24 May 2013

Planning Application EP/61/13/NMA
Electric Gates & Railings at Beltane Close

Drawing Title
Entrance gates and railings

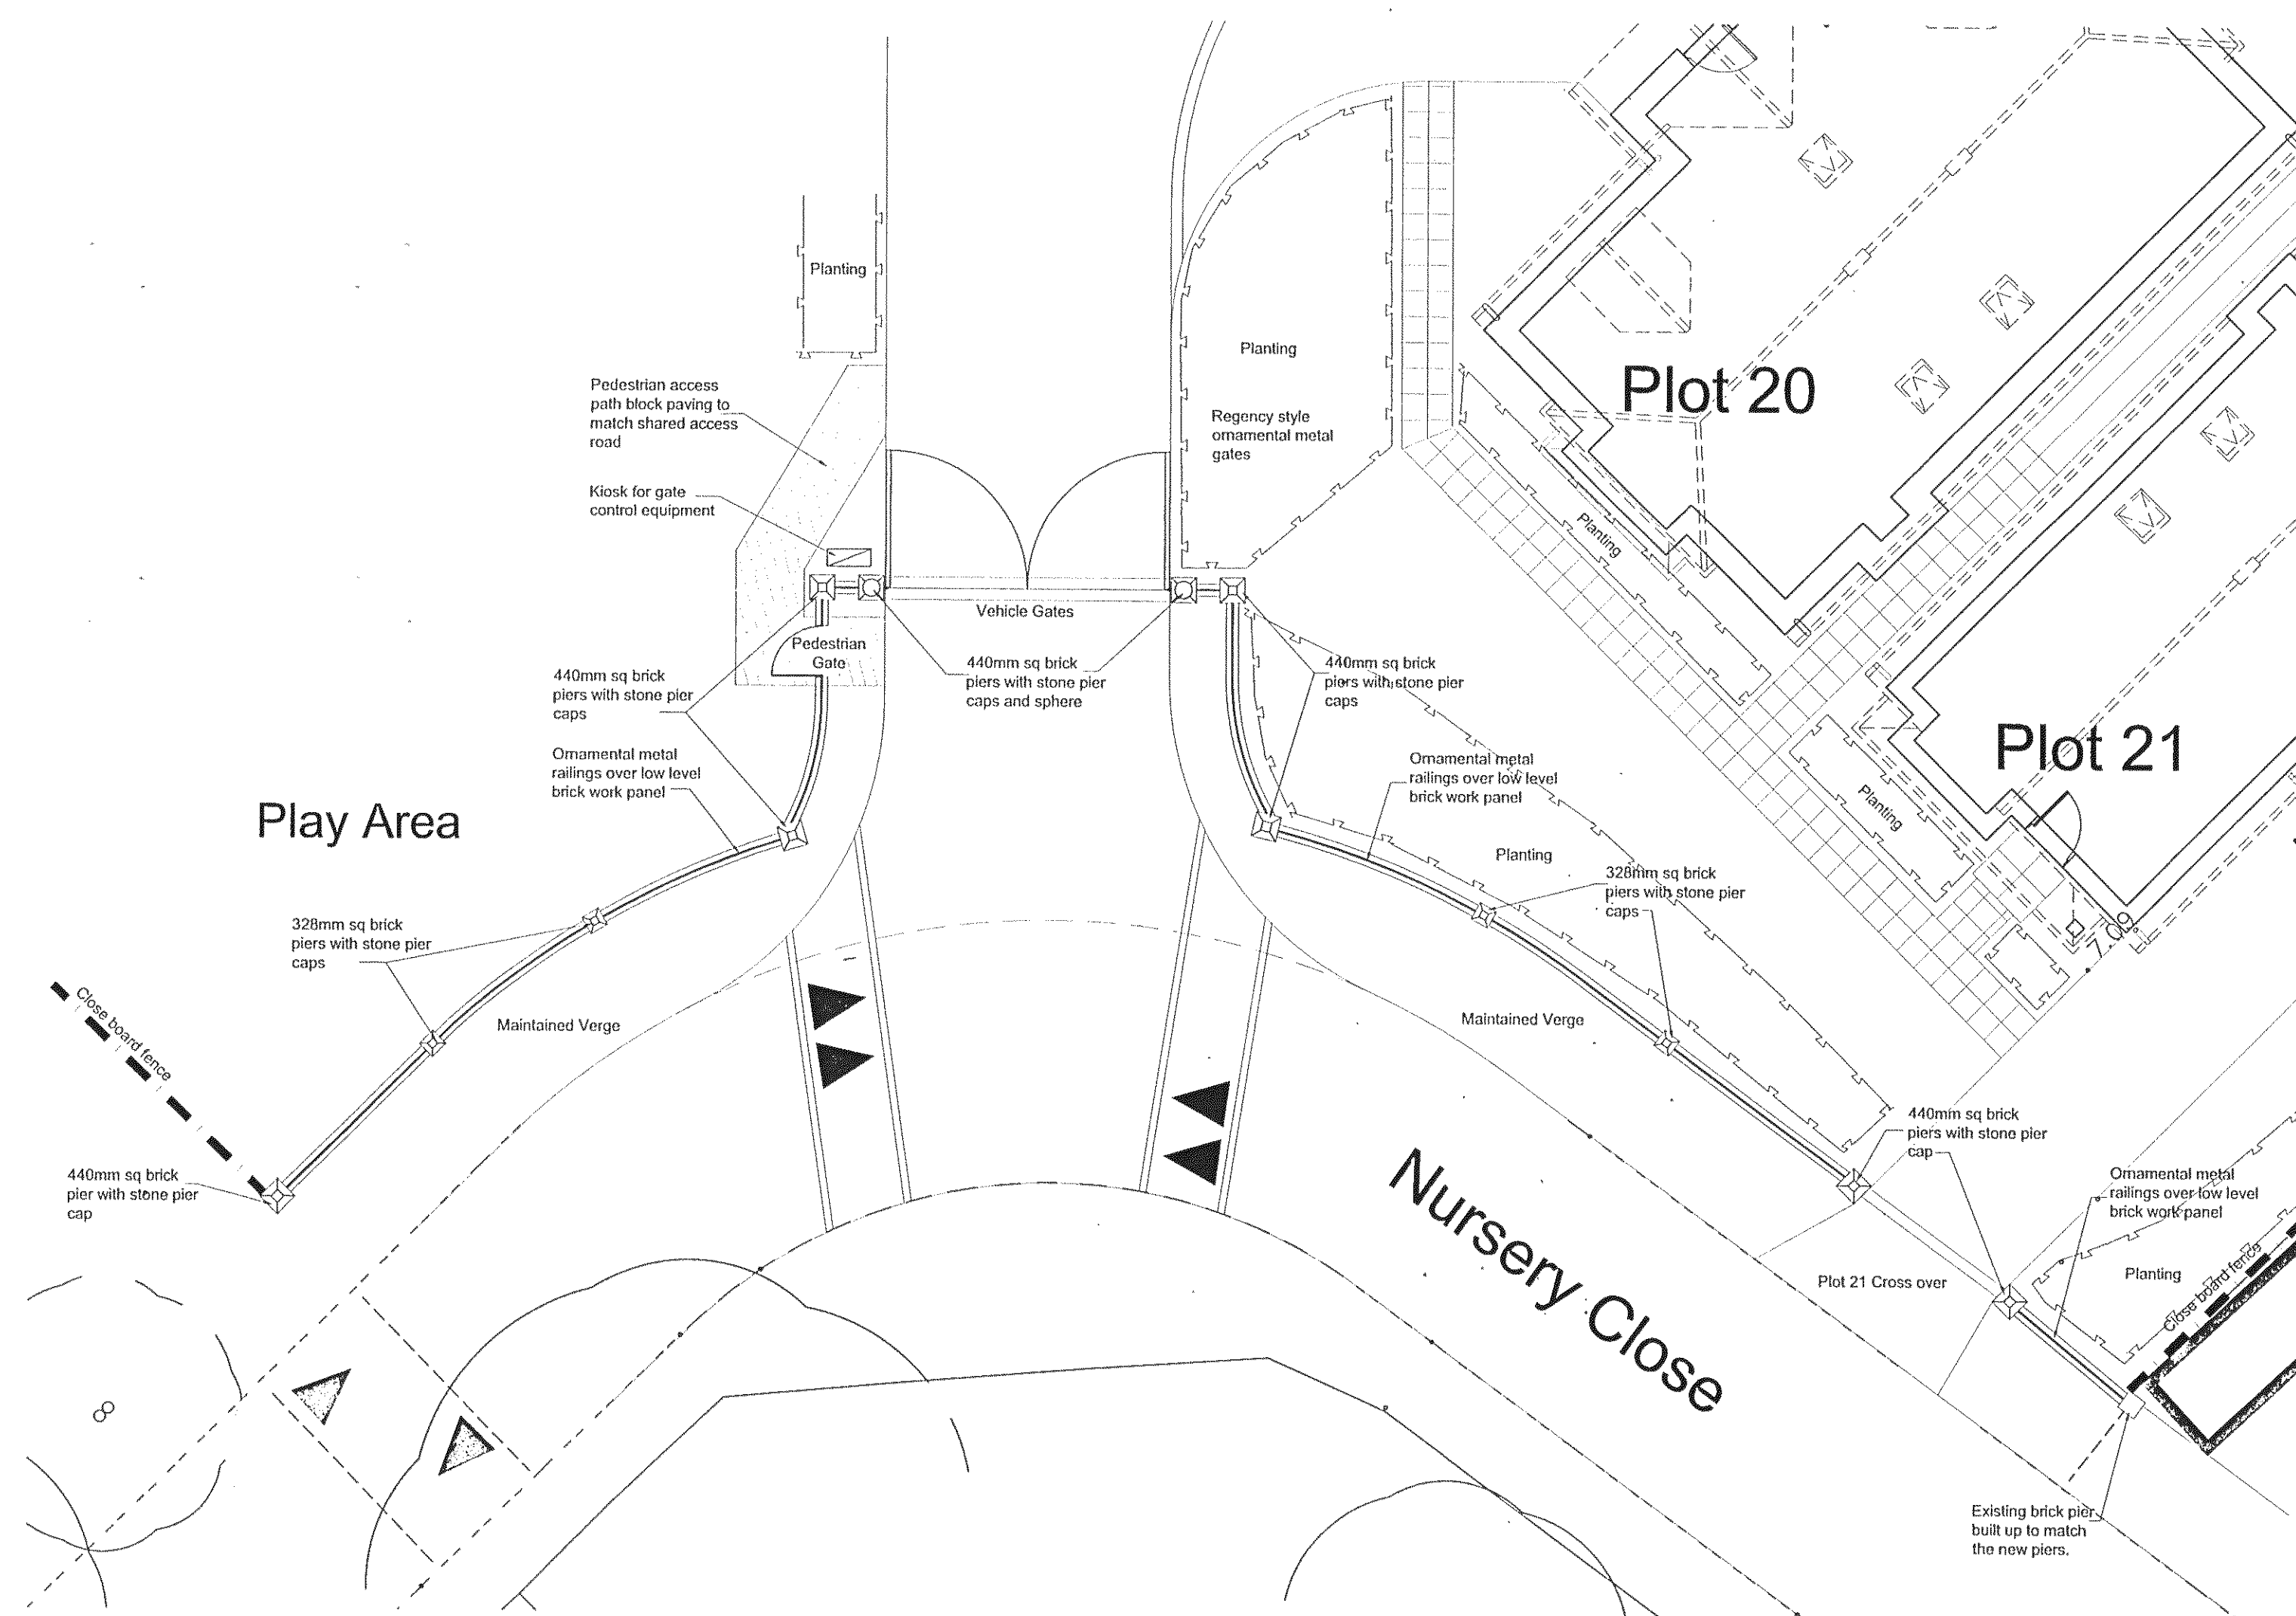
We object to this application on the grounds that the late addition of electric gates and railings is too large an amendment to be submitted as a 'Non-Material Amendment' and should be treated as a full application. It certainly is not in keeping with the existing bungalows in the Close (these have a restriction on the height of their front walls) - nor is it in keeping with the Village Design Statement.

1. The original plans allowed open use of the Area of Play.
2. Strattons advise that the gates are to be set back 'one car's length' to allow for waiting time. A refuse/delivery lorry is three to four times as long as an average car, so if the gates are closed (or fail to open), this would certainly intrude into the road. One assumes that there would be a 'fail-safe' mechanism for if/when the gates break down in the closed position?

3. In view of the extreme narrowness of the Close, it is important to maintain clear entry/exit/access at all times, particularly in regard to emergency vehicles. Even earlier this week, a badly parked delivery vehicle blocked the Close and we were left waiting for over 10 minutes.

4. The proposed height is considered to be intimidating, particularly with the proximity to the road. From about that area, down to the entrance to the Close at Manor Road, there are no facilities for pedestrians. Some residents have electric buggies. How safe is this? When Stratton's site is fully occupied, there will be times morning/evening when the traffic will be heavier; there are now four new entry/exits at the bend for existing residents to deal with.
